<p>This consultation response uses extracts of maps from <i>A66 Northern Trans-Pennine project – Routes for consultation General Arrangement drawings as reference points for comments relating to Cumbria only.</i></p>	<p>Project proposals</p>	<p>Comment</p>
<p>General comments:</p> <ol style="list-style-type: none"> 1. Many opportunities have been missed for providing additional linking public rights of way for pedestrian / pedal-cycle / horse along the whole of the proposed route. 2. Where there are no adjacent minor roads which peds / cyclists / horse riders may use as convenient alternative to the A66 such provision should be made as part of the A66NTP project. 3. Some of the proposals relating to public paths are outside of the red-line. Does this mean that they will not be covered by the DCO and will have to be done by CCC? 		
<p>Statutory Consultation legend (p5)</p> 		<p>Change notation that gives much clearer indications of sections of routes that are the extinguished and created as part of diversion proposals.</p>

GW 01.11.2021

Drawing Title: Classification of Roads Plan Regulation 5(2)(o) Sheet 2 of 2

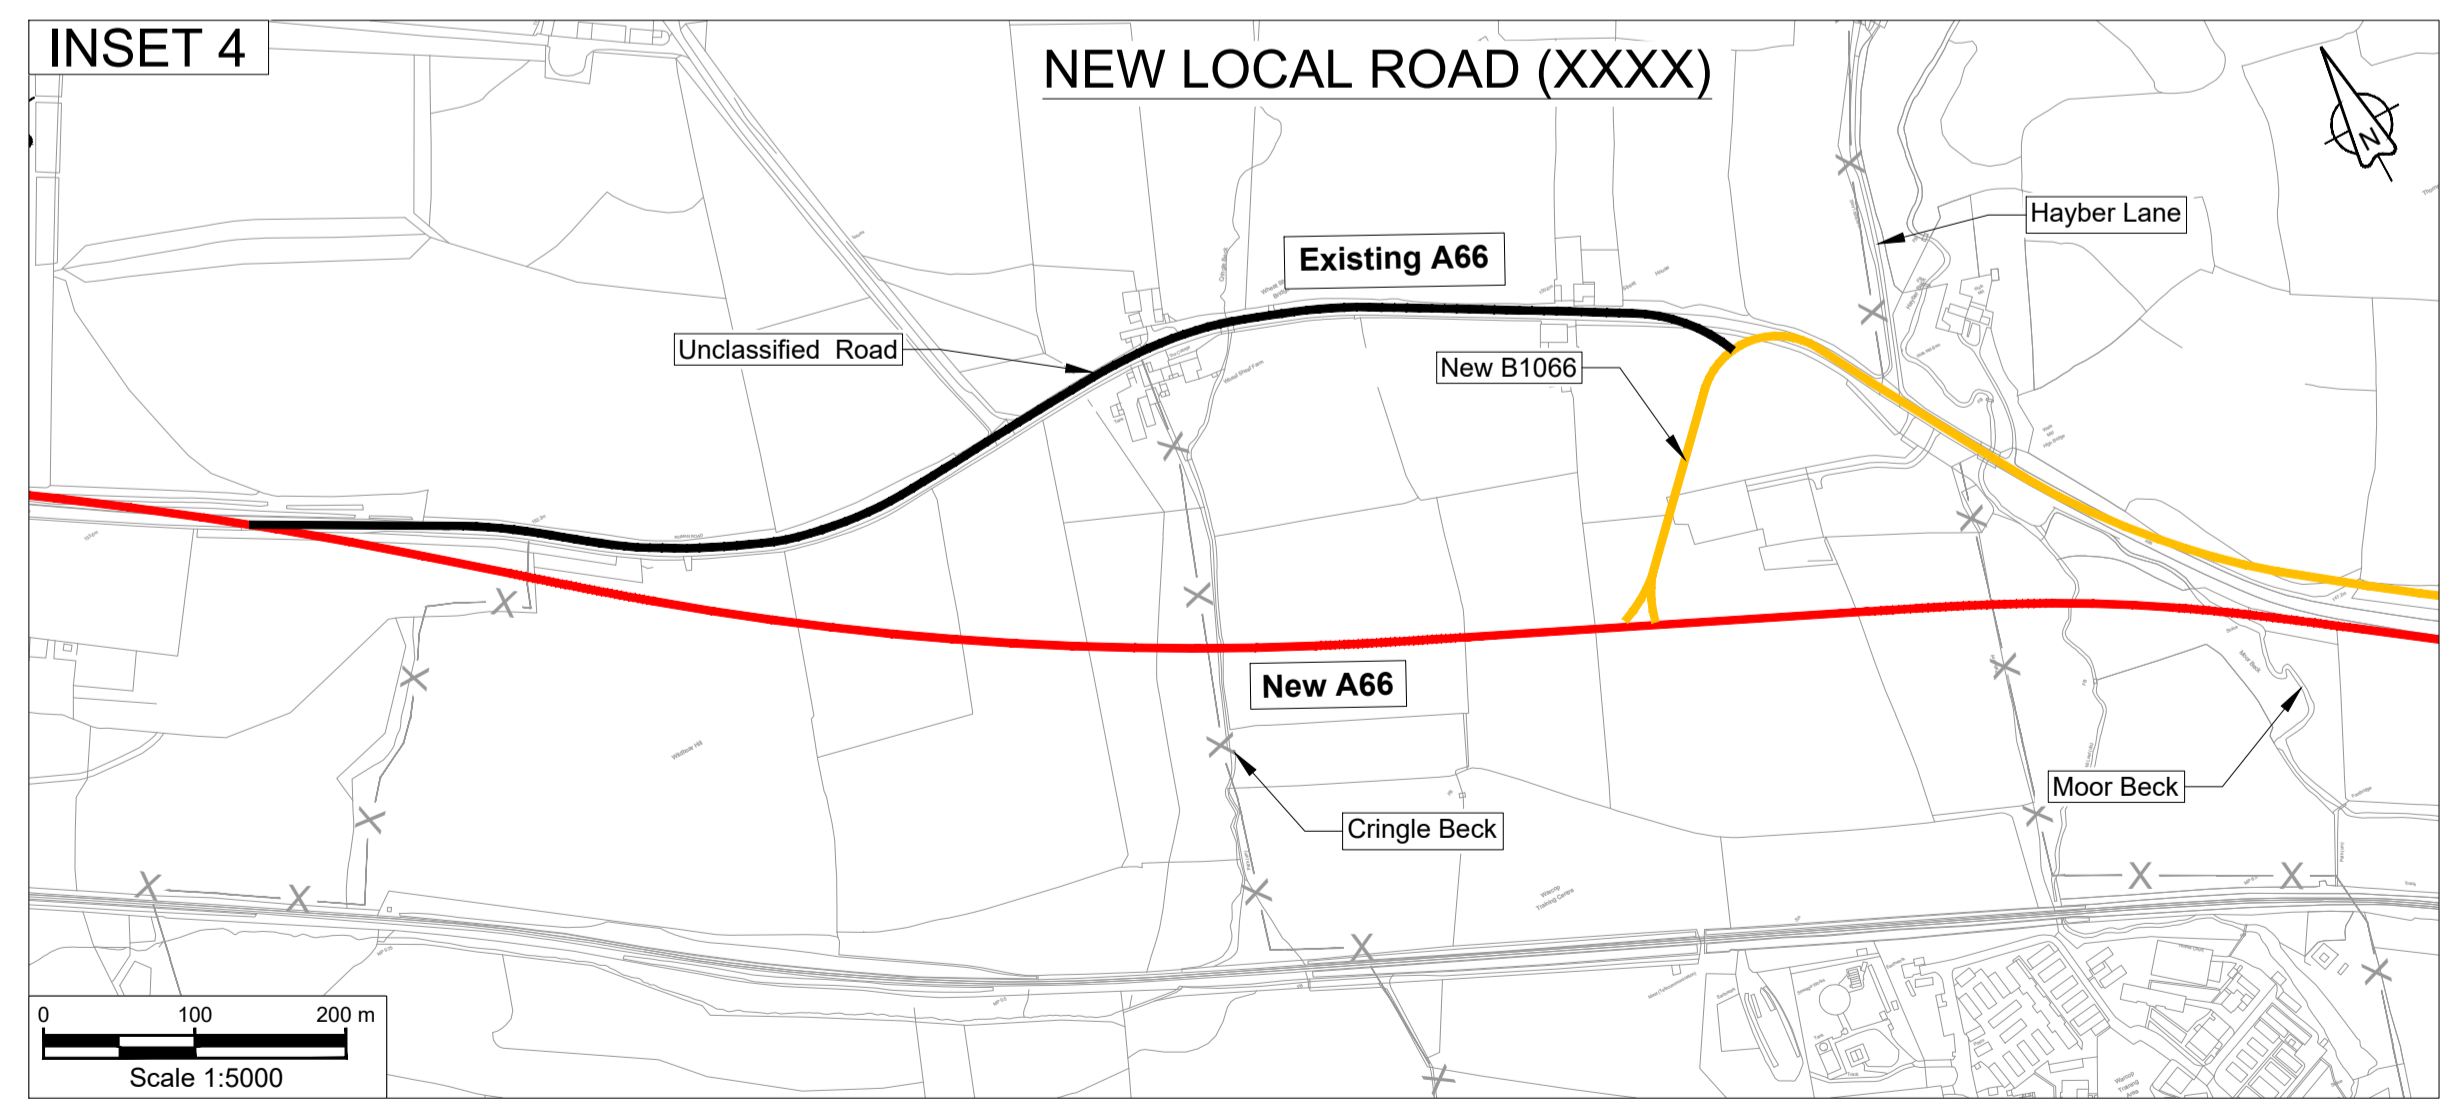
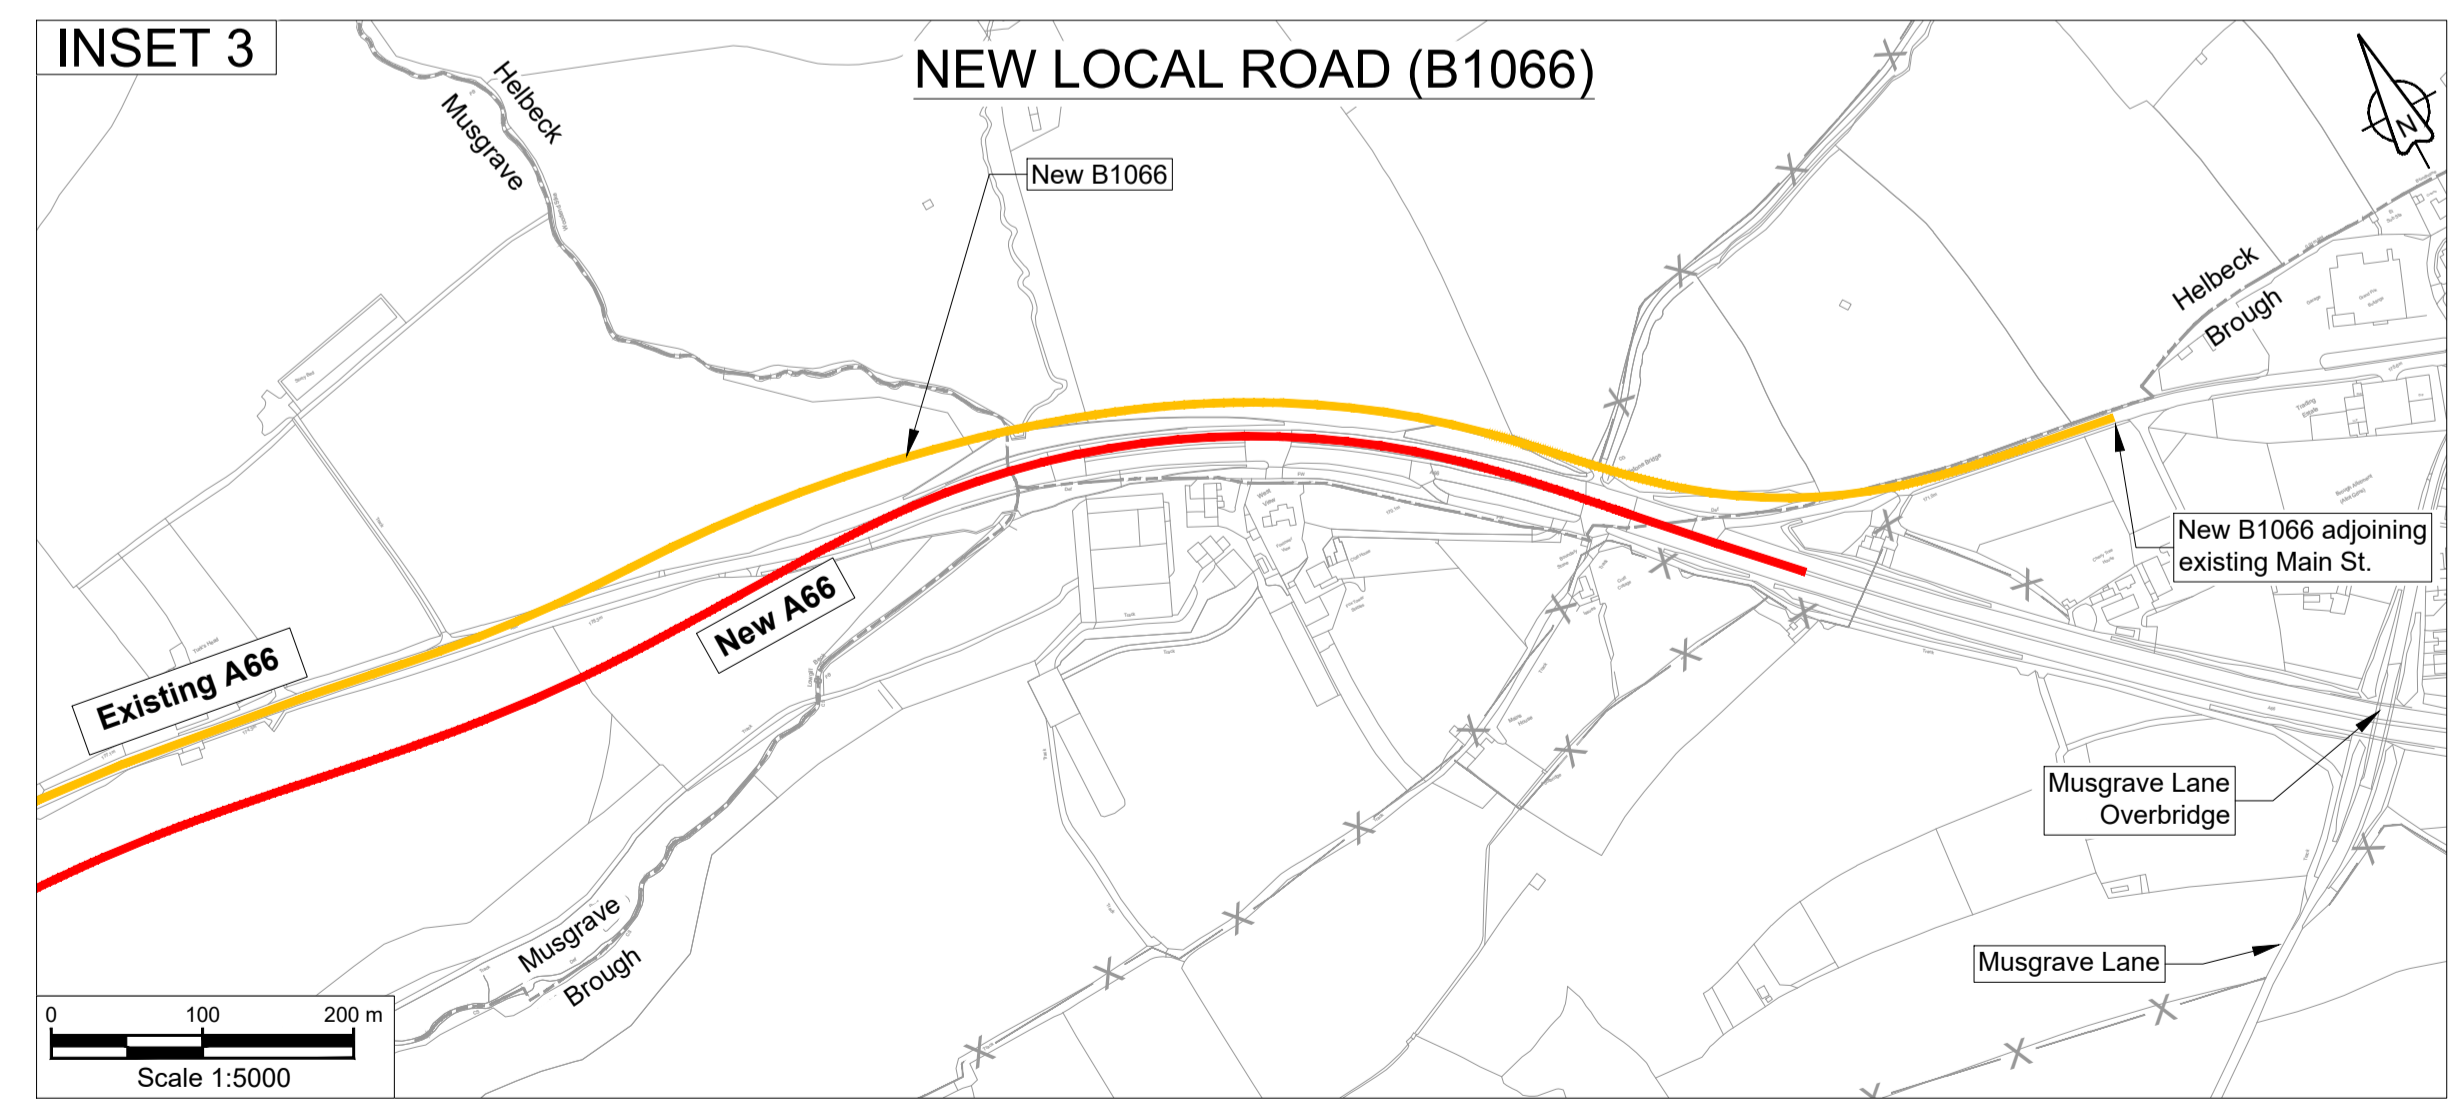
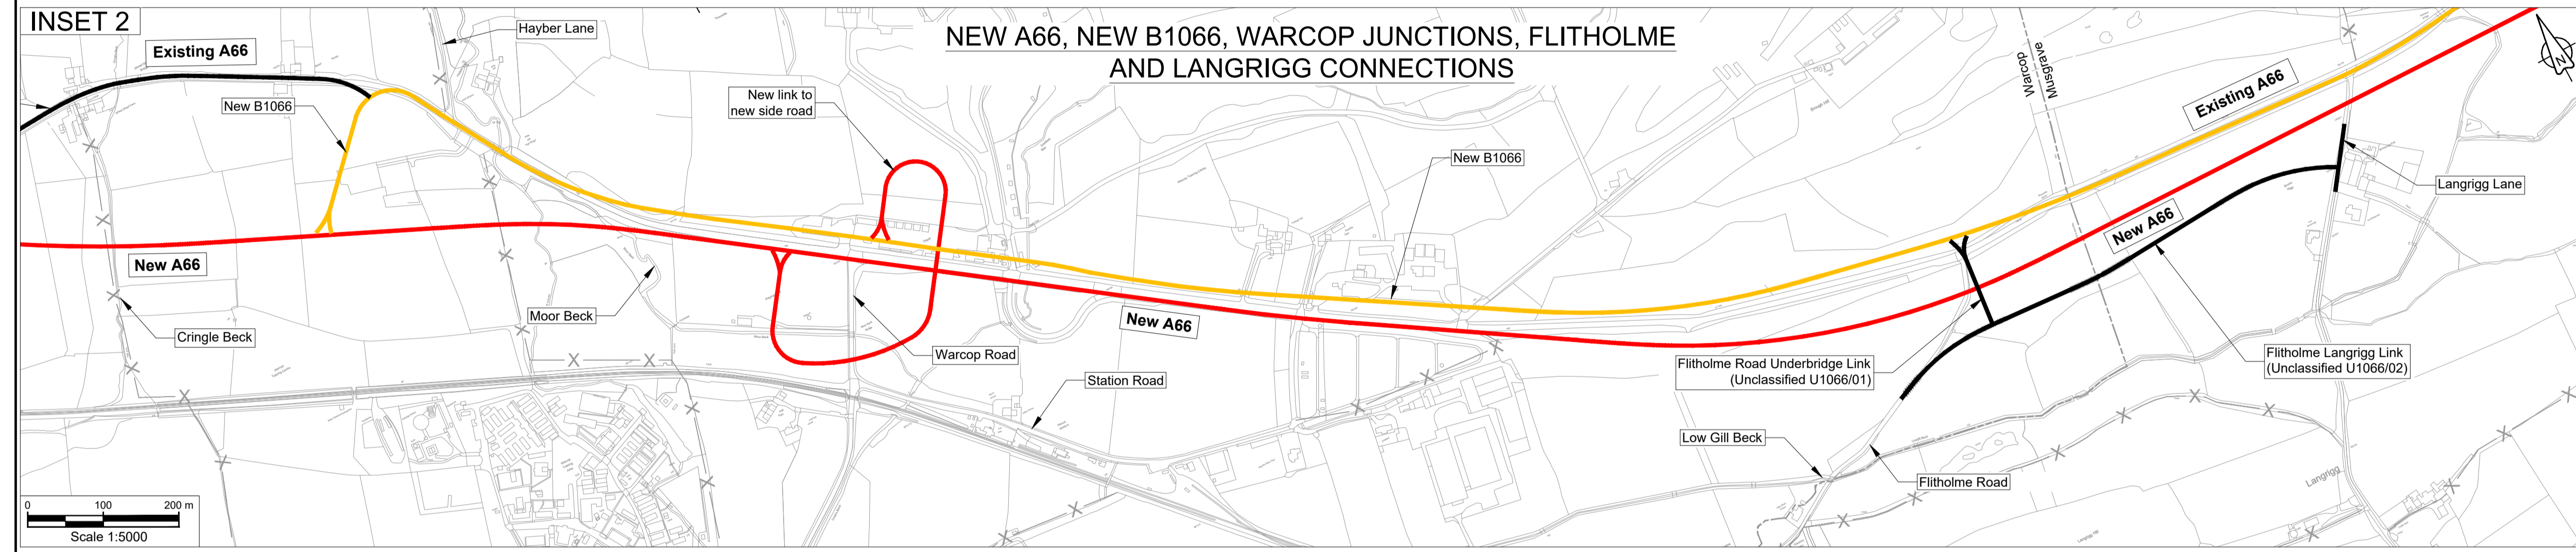
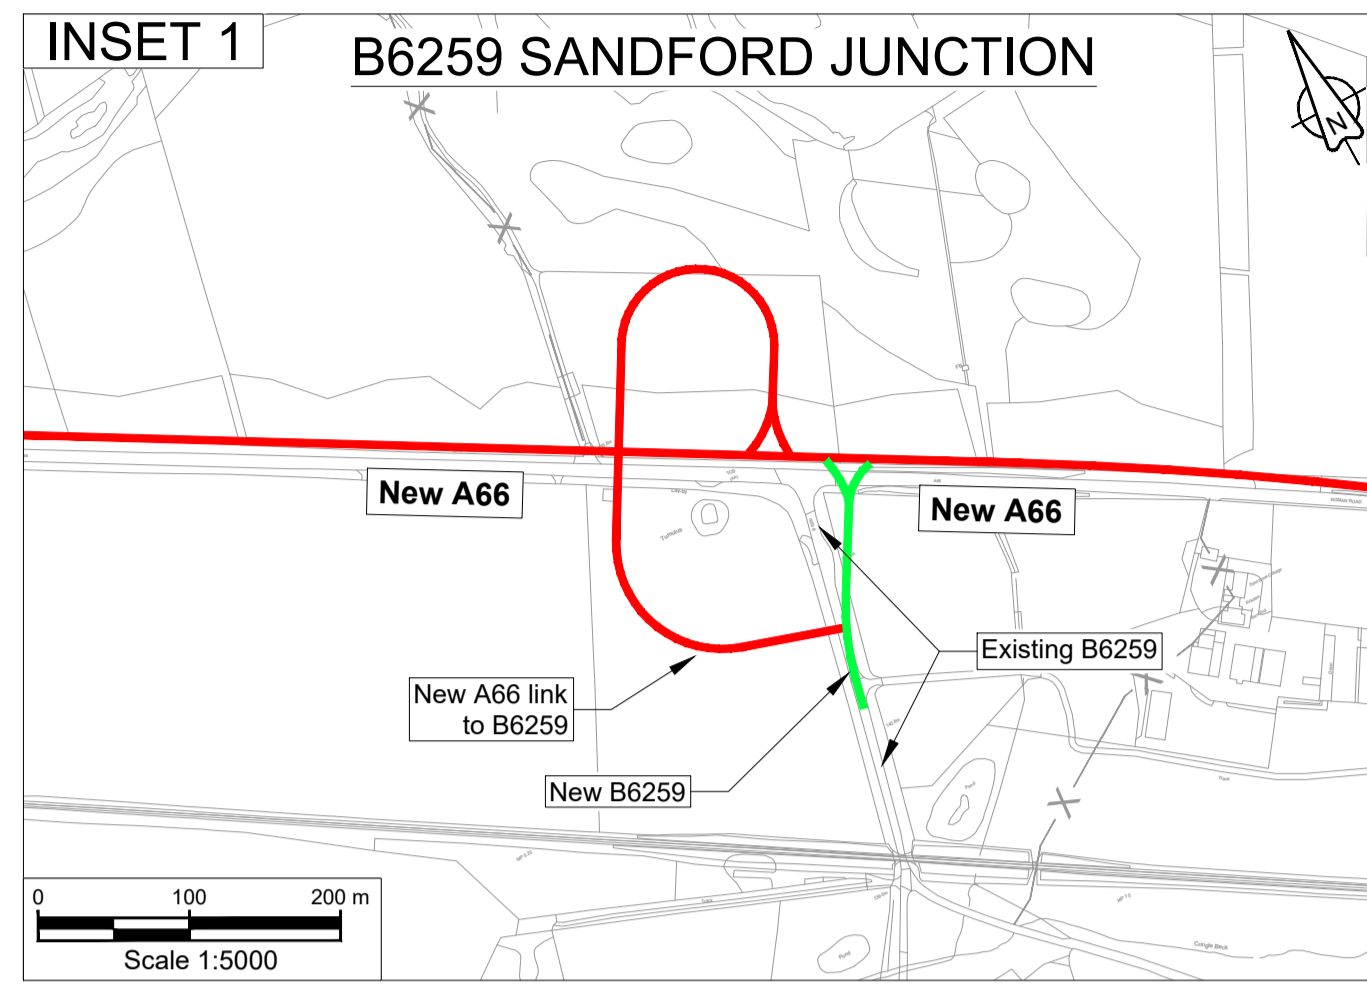
<p>If road to rear of Ketland Moor / Café 66 is to be new east-bound link to U3261 then a short section of FP 372028 is being extinguished (not diverted).</p>	<p>Status of road to Far Bank End level crossing (U3261) needs to be retained.</p>
<p>Appleby to Brough (p25) – Sandford Junction</p>	<p>Project proposals</p> <p>FP 372027 to be diverted onto Sandford Junction (B6259) west-bound slip road (and bridge).</p> <p>FP 372022 to be diverted to terminate at B6259.</p>	<p>Comments</p> <p>Proposals are outside of the red line. Section of proposed FP 372027 diversion route is superimposed on diverted B6259.</p> <p>Is this a mapping error? Or is a definitive FP to be created alongside the B6259? Or is the path alongside the B6259 to be part of the B6259 (a footway)?</p>

<p>Sandford Junction (B6259)</p> <p>Dyke Nook Cottage</p> <p>FP 372027</p> <p>FP372022</p>		
<p>Appleby to Brough (p25) – Wheat Sheaf Farm</p>  <p>Wheat Sheaf Farm</p> <p>A66</p> <p>Wildboar Hill</p> <p>FP372014</p> <p>FP372013</p>	<p>Fps 372013 & 372014 to be diverted via a common underpass at Wheat Sheaf Farm, and drainage pond access road.</p>	<p>Proposals are outside of the red-line.</p>
	<p>Project proposals</p>	<p>Comments</p>

FP 372021 to be diverted via underpass to new termination with old A66 east of Street House.

Is a definitive FP to be created alongside the Warcop EB slip-road? Or is the path alongside the slip-road to be part of the slip-road and consequently part of the highway (a footway)?

FP 372020 to be diverted parallel with S side of new A66 carriageway.

Diverted FP 372020 should be upgraded to bridle way to create BW / cycle link between C3070 / U3309 at Warcop East to U3311 at Flitholme and U3312 at Langrigg.

Is section of new diverted path along west-bound access road alongside the access-road? Or is the path to form part of the highway (a footway)?
